Application number: 2021/90702	
What is the application for?:	Variation conditions 2 and 3 on previous permission 2018/94167 for erection of d
Address of the site or building:	adj, 27, Riley Park, Kirkburton, Huddersfield, HD8 0SA
Postcode:

Proposed Site Plan 1:200

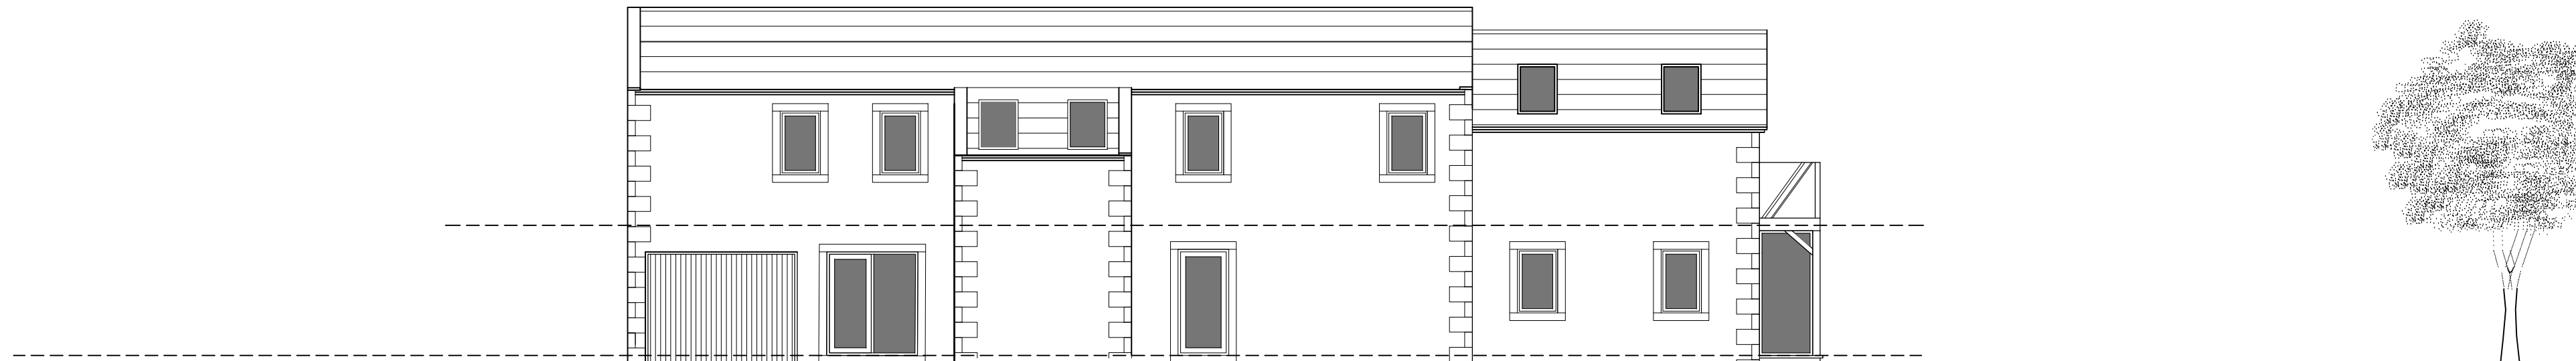
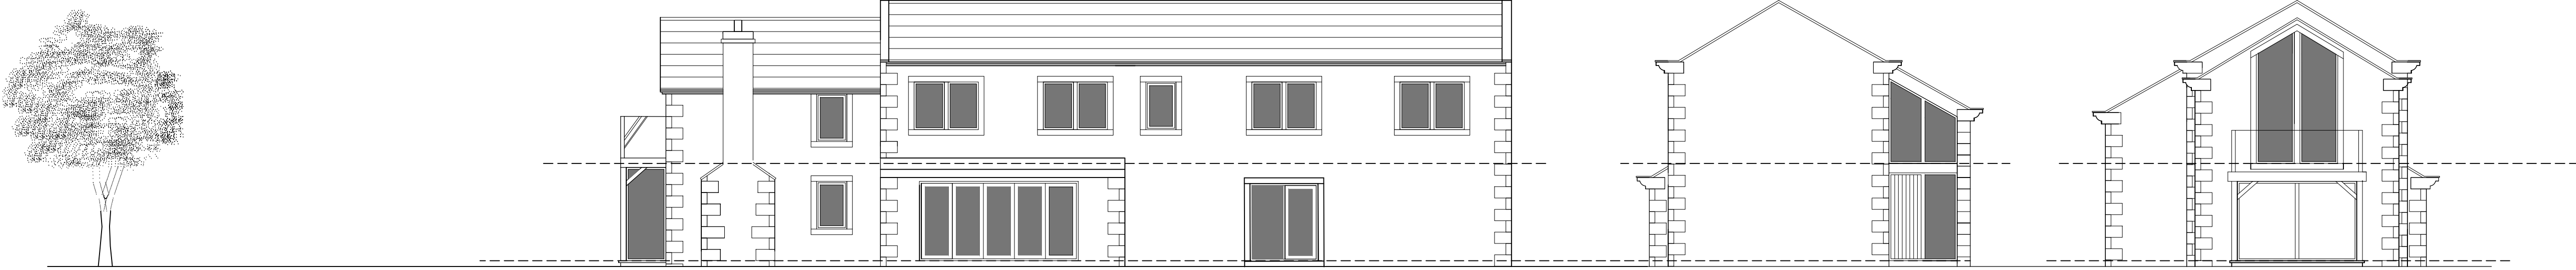
All other properties around this banking have substantial retaining walls. In one of these retaining walls can be see a significant crack. Potential further evidence that the banking is unstable and moving. This new building despite being built very close to the edge of a 30ft near vertical banking has no retaining wall. The method of construction to ensure the integrity of the banking against collapse should be provided.

The bottom of the banking belonging to the plot on which this new building will be built is in flood zone1 and has seen previous flooding. The construction of this new building will increase flood risk and therefore the Environment Agency should be asked to review their risk assessment.
